Engineers Comments Regarding Surface Water Drainage

Application Reference:	AL/118/25/DOC	Reviewer Reference:	ADC/EXT5/AF
Planning Officer:	Amber Willard	Date of Review:	26/02/2026
Site Name:	Land to the North of The Haven and East of Northfields Lane Westergate PO22 3UH		
Application Description:	Approval of details reserved by condition imposed under AL/104/25/S73 (APP/C3810/W/25/3358593) relating to condition 4-surface water drainage (see AL/118/25/DOC for discharge of conditions 3-Construction Environmental Management Plan, 7-Biodiversity Enhancement Plan, 10-Natural England licence and statement and 12-lighting).		
Assessment Number:	2

FLOW CONTROL CHAMBER

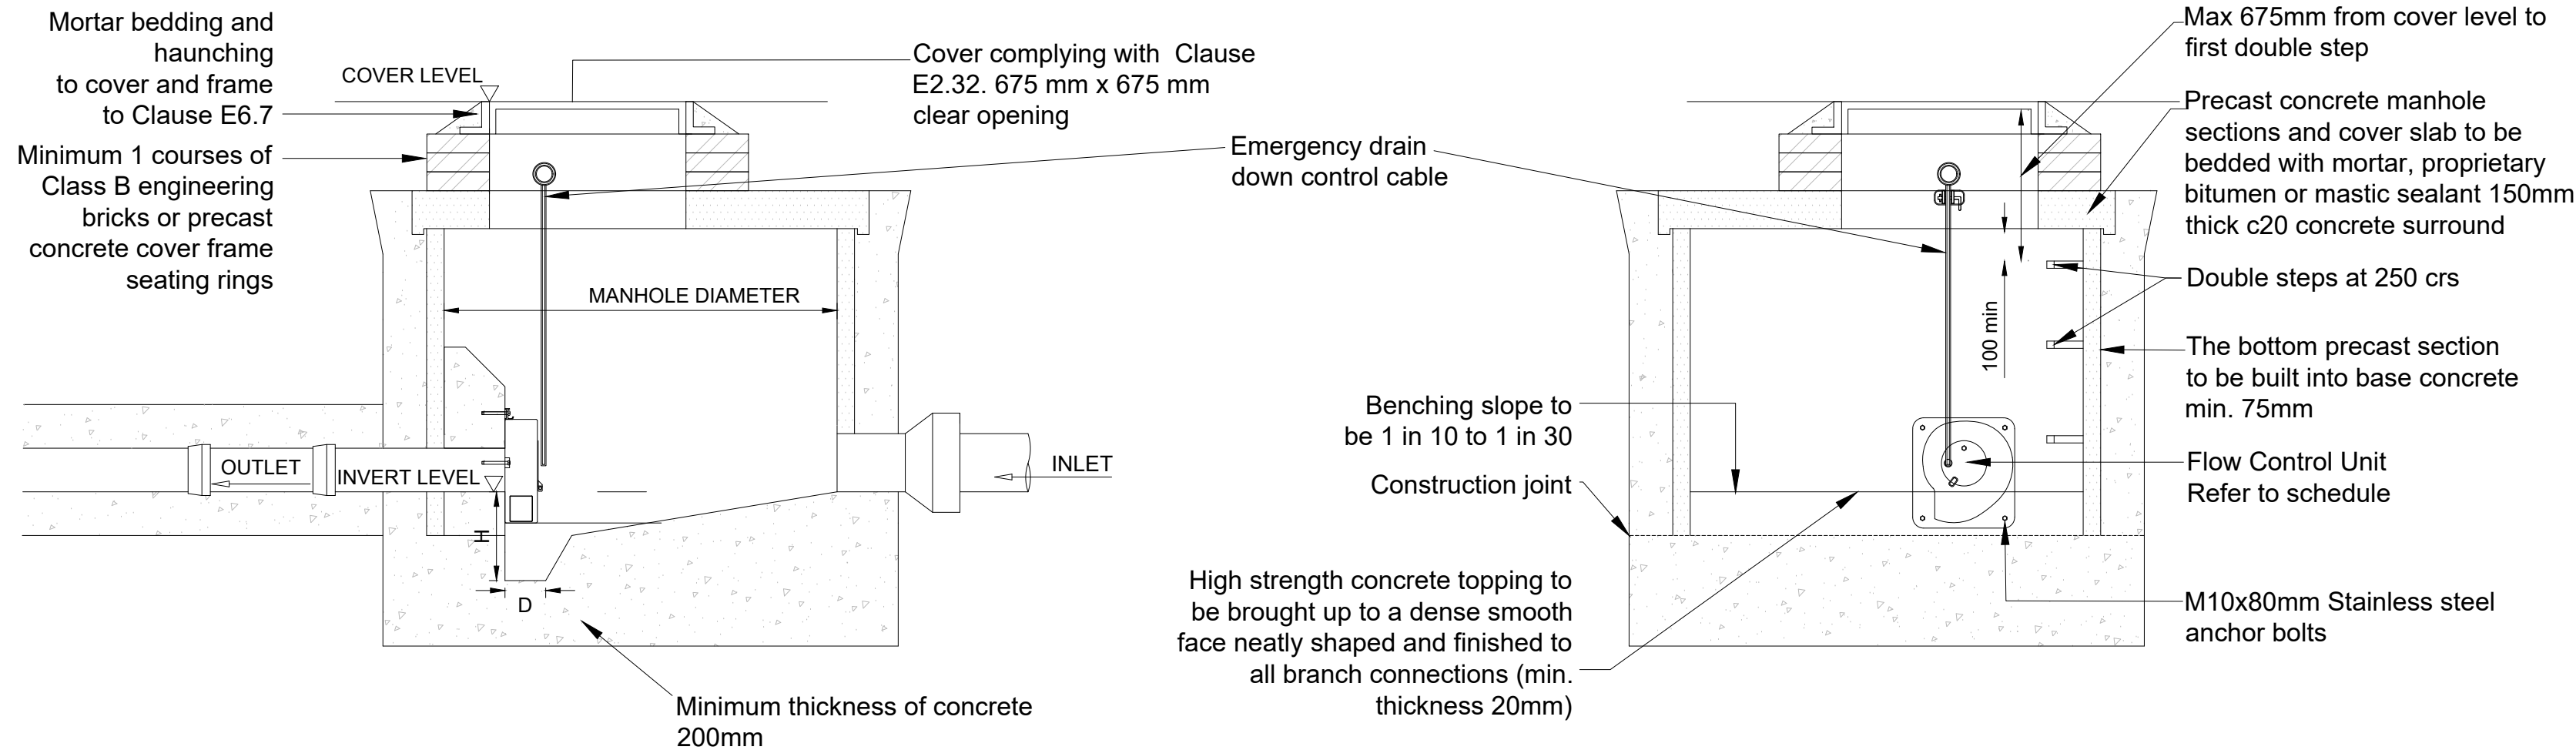
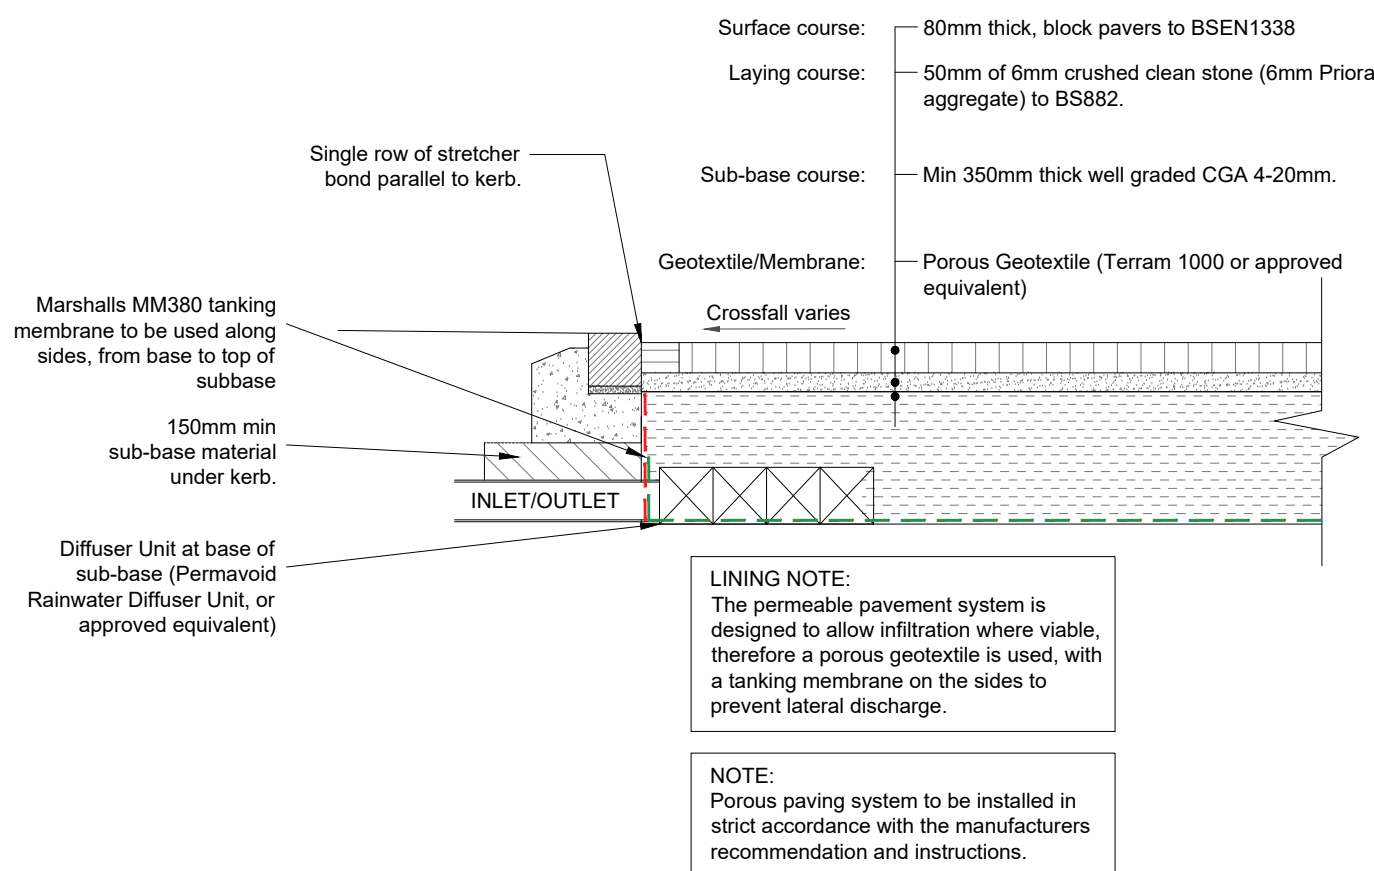
5.	The proposed design peak outflow rates are arbitrary and not restricted to greenfield runoff rates in accordance with the National SuDS Standards. Design flow restriction should be based upon greenfield runoff equivalent for the drained area and if necessary a relaxation applied where constraints preclude meeting the GFR rate. Modern flow	Peak outflow will not be reduced by rainwater harvesting or infiltration in this case. The NSfS states 'Where the peak allowable discharge rate requires flow controls with orifices (or equivalent) with a diameter of less than 50mm, the flow control shall be robustly protected from blockage risks. Regardless of this, the risk of blockage for all flow controls shall be assessed and mitigated against.' There	Design has been amended to utilise SuDSStore Controflow Universal chambers, which utilise orifice flow controls and a protection filter. The manufacturer states that: "Applications – all SuDS elements, particularly those that do not provide filtration for orifice protection and at the end of the management train" The unit is therefore	The design still does not make an effective case for relaxation of Standard 3 of the NSfS in terms of peak flow restriction to Greenfield Runoff. The greenfield runoff calculation in the DS is for the site area whereas the calculated GFR should be based upon the <u>drained area only</u> . I cannot see calculations for this area (0.058ha) in the report.

controls can achieve rates much lower than 1l/s. Designer Response 09/01/2026 Harbournstone has concerns about designing to very low discharge rates (e.g., -inability to meet required 24-hour half-drain down times with very low discharge rates, -operational reliability under fine flow conditions, and -potential for surface water flooding due to blockage incidents. Industry Guidance cautions use of very low discharge rates due to the above reasoning, including but not limited to the National Standards for SuDS and CIRIA. It is worth noting also that discharge rates will be reduced by any viable infiltration within the permeable pavement (with allowance for infiltration not modelled but where possible provided for, as advised by ADC Drainage) as well as via rainwater harvesting.	are products on the market which include integral blockage protection for small diameter flow controls. Hydrobrake Optimum would not be the correct flow control device specification for achieving the lowest rate reasonably practicable. 5 times GFR would appear to be 0.8 l/s total for the site. Upstream measures can also be incorporated to manage blockage risk.	appropriate, not withstanding that permeable pavement will provide primary treatment to runoff from the driveway. Proposed runoff is now 1.2 l/s in a 100-year design storm event (and 0.9 l/s in a 1-year storm event). Greenfield rate for the site is 0.8 l/s, as well as the Q-100 rate being 2.5 l/s. The proposed discharge rate is therefore now approximately at existing Greenfield rate for the site, and less than the 5XGFR rate referred to (4.0 l/s). The amended design has aimed to reduce runoff rate as close to permeable pavement as possible, in accordance with the published Arun DC guidance, and it is requested that this is now considered appropriate. If considering the GFR of only the proposed catchment area, the proposed runoff rate is now roughly or less than 5XGFR also	Where this is too low to achieve on a reasonably practicable basis evidence needs to be provided that measures are in place to achieve the lowest rates approaching greenfield runoff and no more than 5 times GFR rate. This is not clear from the DS or the response. It is likely that 5xGFR is lower than that currently proposed as a total discharge from the site and that special consideration of blockage risk reduction upstream of the flow control will be needed and potentially a rate agreed per chamber which is lowest feasible once effective blockage protection is employed.

PERMEABLE DRIVEWAY BLOCK PAVING CONSTRUCTION DETAIL

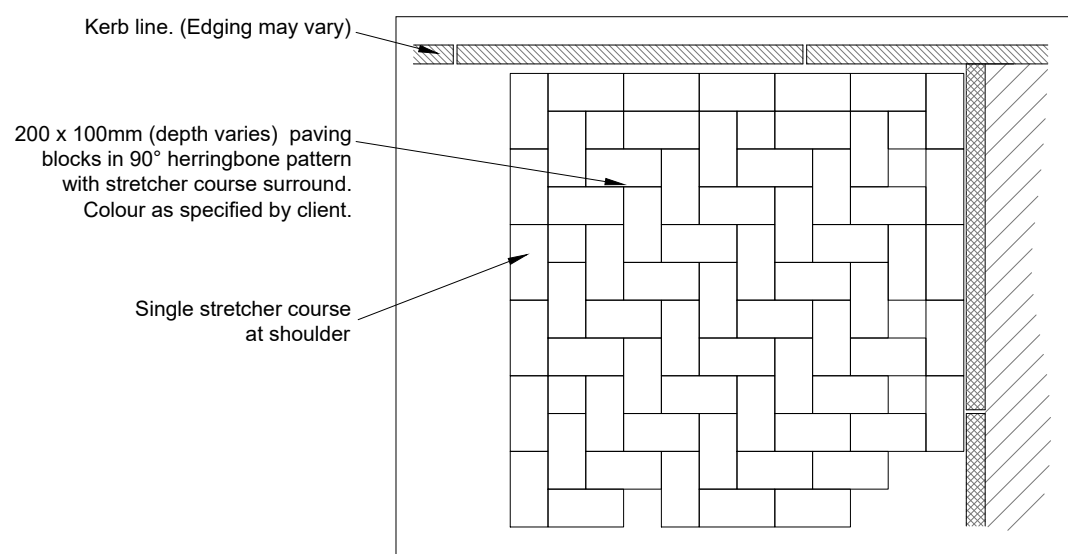
3.	The design does not include provision of Interception Drainage in accordance with the National SuDS Standards Designer Response 09/01/2026 the design does include interception drainage via permeable pavement and rainwater harvesting, consistent with Arun District Council's interception drainage guidance - Arun District Council, and with	The permeable pavement is within 1m of the water table and will need to be lined. Rainwater harvesting would need to be specifically designed for interception drainage. Details are not provided on the drainage layout and construction details. Please provide a design for interception drainage	Rainwater harvesting details have now been provided, noting the change in permeable pavement specification requirements and the change in policy that this is no longer considered interception drainage. GreenBlue Urban SuDS Pod to be utilised. Manufacturer has provided construction details and modelling information to include within hydraulic	The design for interception drainage does not appear to meet the criteria within NSfS. The lined permeable pavement is acceptable for self-drained area. The roof areas can be served by swales, or other vegetated areas and should be supported by calculations in the report to confirm the areas are sufficient.

National standards for sustainable drainage systems (SuDS). This was previously submitted so please re-review		modelling. Unit will provide interception drainage at surface and attenuation.
